Arborist Report

TO: Rouslana & Leonid Yaroslavsky
SITE: 9319 SE 43rd Street, Mercer Island, WA 98040
DATE: March 31, 2021
PROJECT ARBORISTS: Joseph Sutton-Holcomb
ISA Certified Arborist #PN- 8397A
ISA Qualified Tree Risk Assessor

REFERENCED PLANS: "Combined Permit Set" Métrica LLC, dated 03.31.2021
ATTACHED: Table of Trees, Annotated Survey

Drawing Title:
TREE PROTECTION PLAN

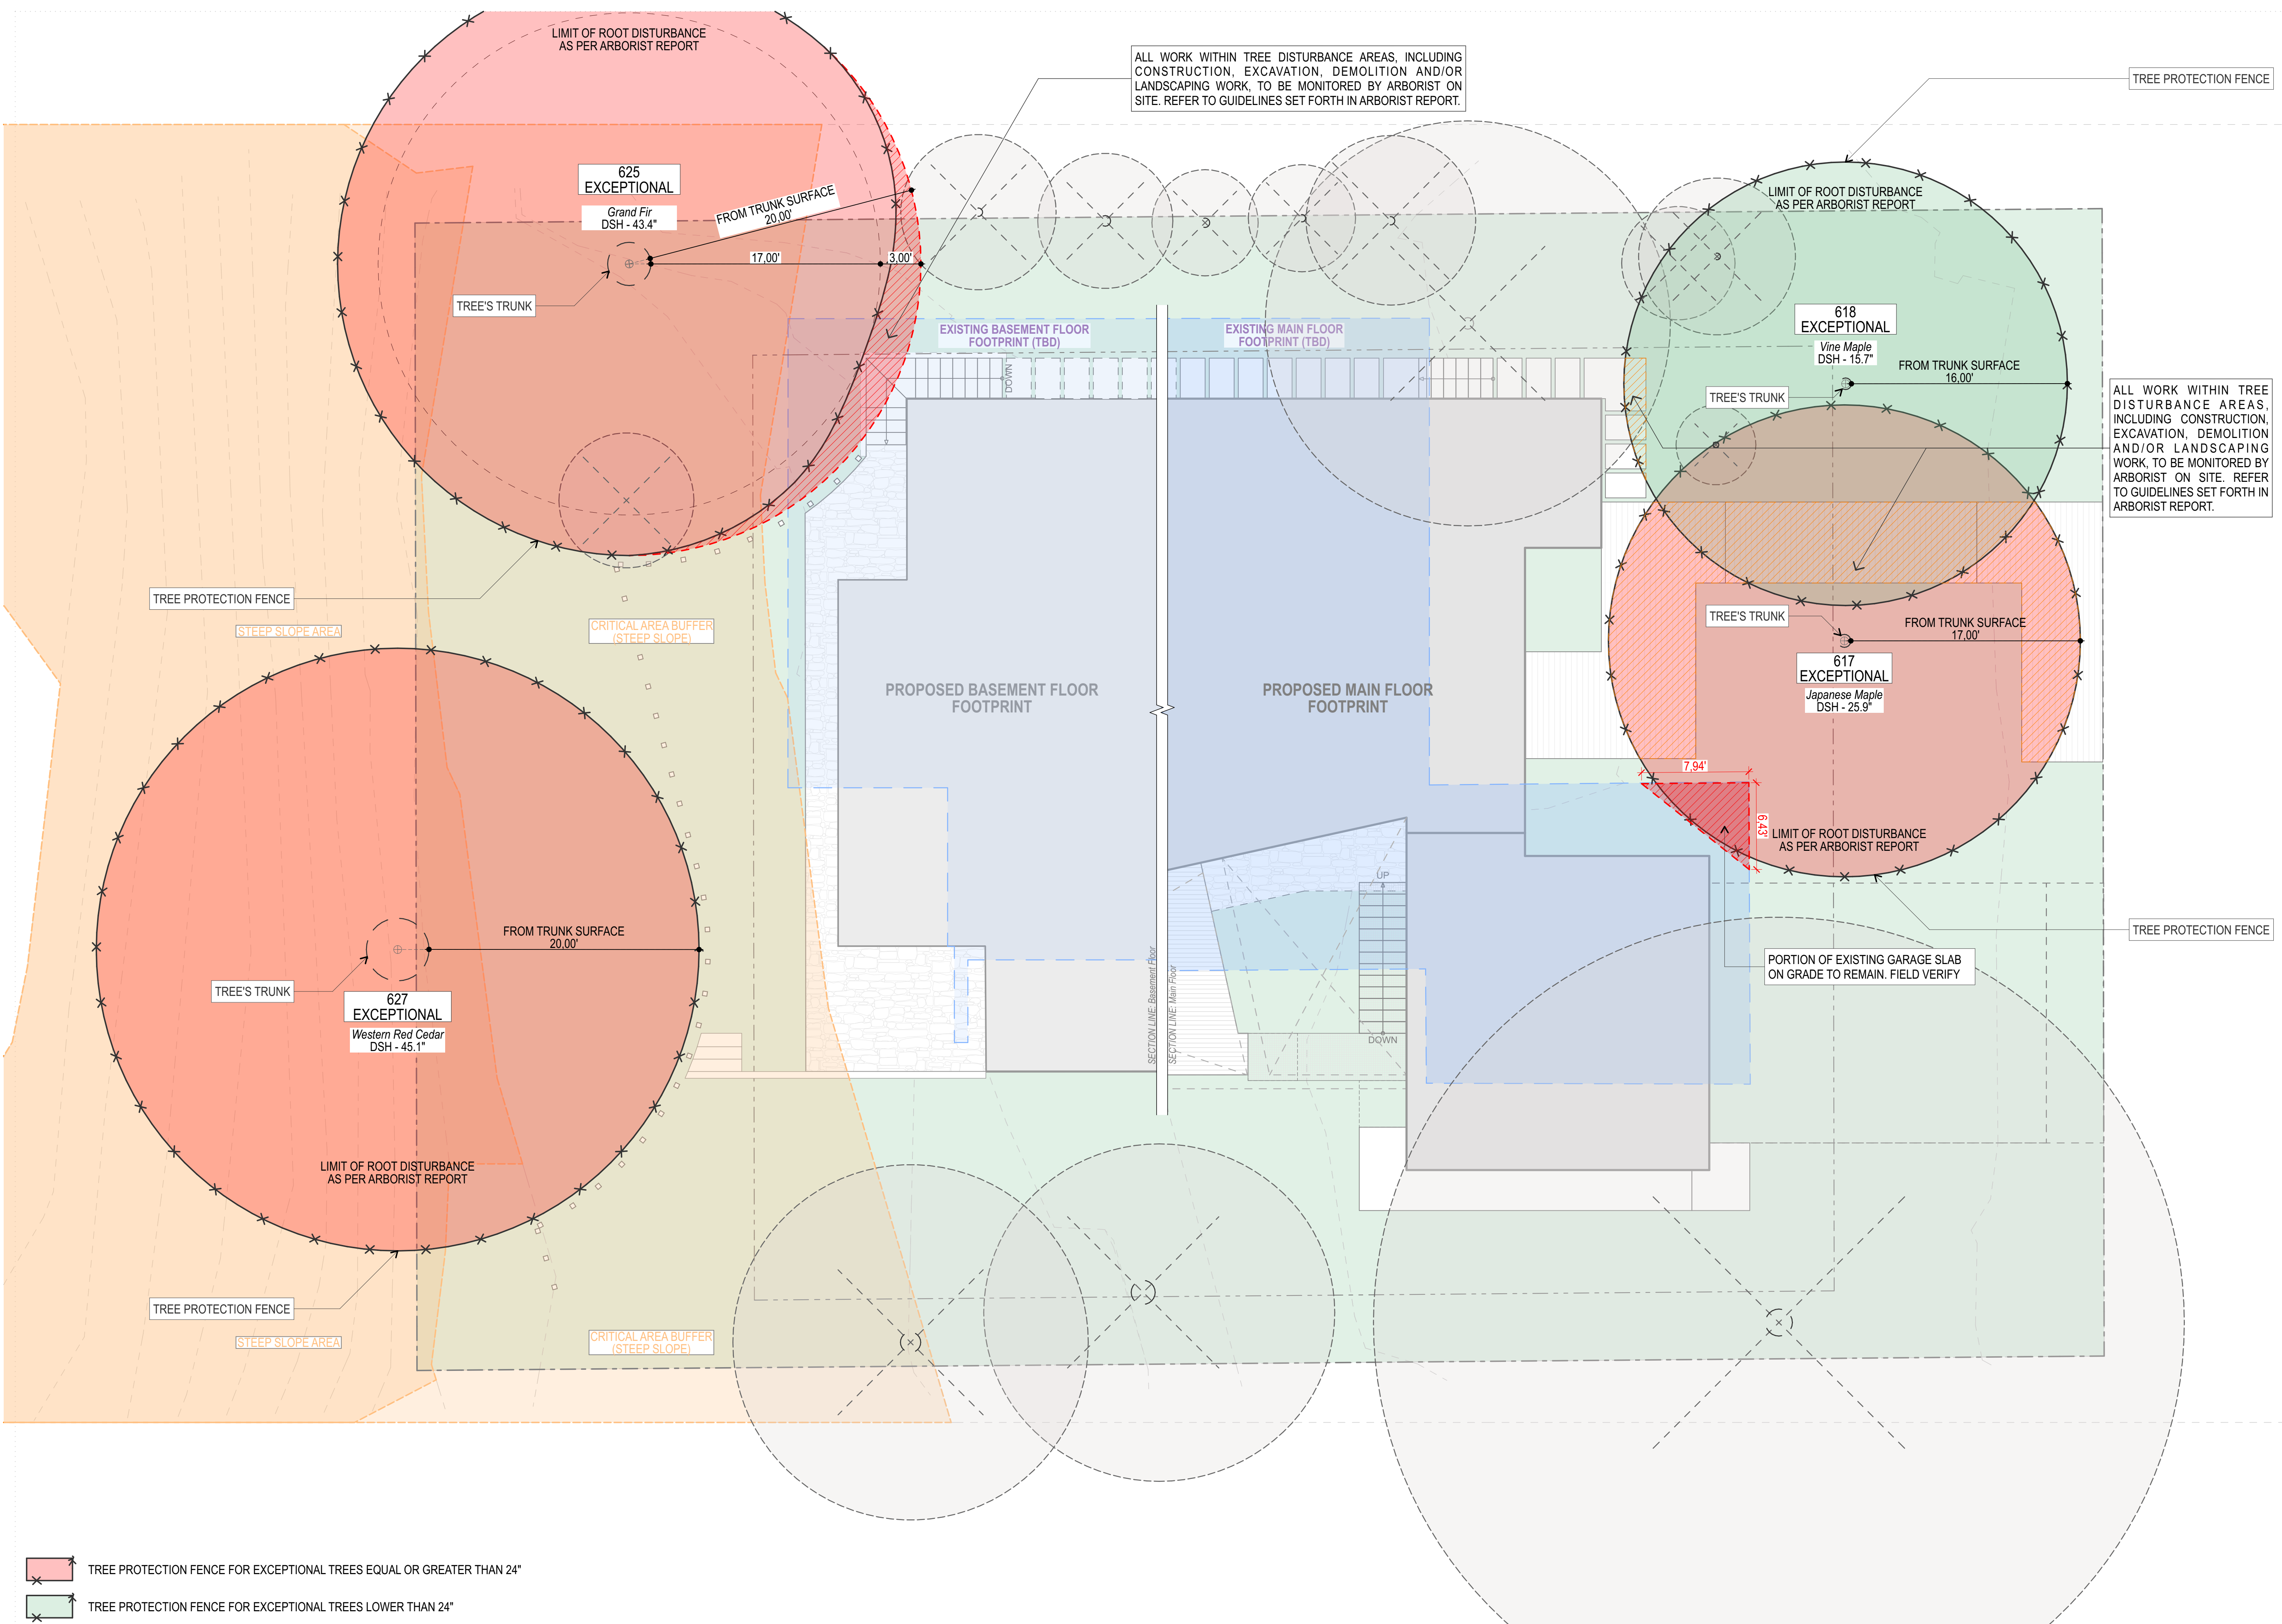
Application of woodchip mulch and supplemental irrigation should be specified on the tree protection plan.

Removal of any hardscape within the dripline of this tree must be done with extreme care to avoid damaging the roots of the tree. The plans I have reviewed show removal of existing asphalt and installation of a hardscape path in close proximity to the tree.

All work within the limits of disturbance is called out for monitoring on the Tree protection plan. In my opinion, if all demolition of existing hardscape and installation of new hardscape is monitored, and the builders work with the project arborist to minimize tree impacts, this tree can be successfully retained on the site.

Application of woodchip mulch and supplemental irrigation should be specified on the tree protection plan.

The tree is shown as fenced at the recommended limits of disturbance on the tree protection plan. If all work within the limits of disturbance, including demolition of existing hardscape, and any new excavation or grade change, is monitored by the project arborist, this tree can be successfully retained on the site.

Removal of invasive species and debris near trunk, application of woodchip mulch, and irrigation should be specified on the tree protection plan.

The plans I reviewed call out arborist monitoring for all demolition and construction work within the limits of disturbance, and show only minimal impacts beyond the footprint of the existing house. These impacts are for installation of stairs and retaining walls associated with the back yard and accessory dwelling area on the lower level.

Application of woodchip mulch and irrigation should be specified on landscape plan.

The plans I've reviewed show no impacts within the provided limits of disturbance. A landscape wall is proposed immediately outside of the limits of disturbance. In my opinion, this impact is acceptable, provided the tree is mulched with woodchips and irrigated.
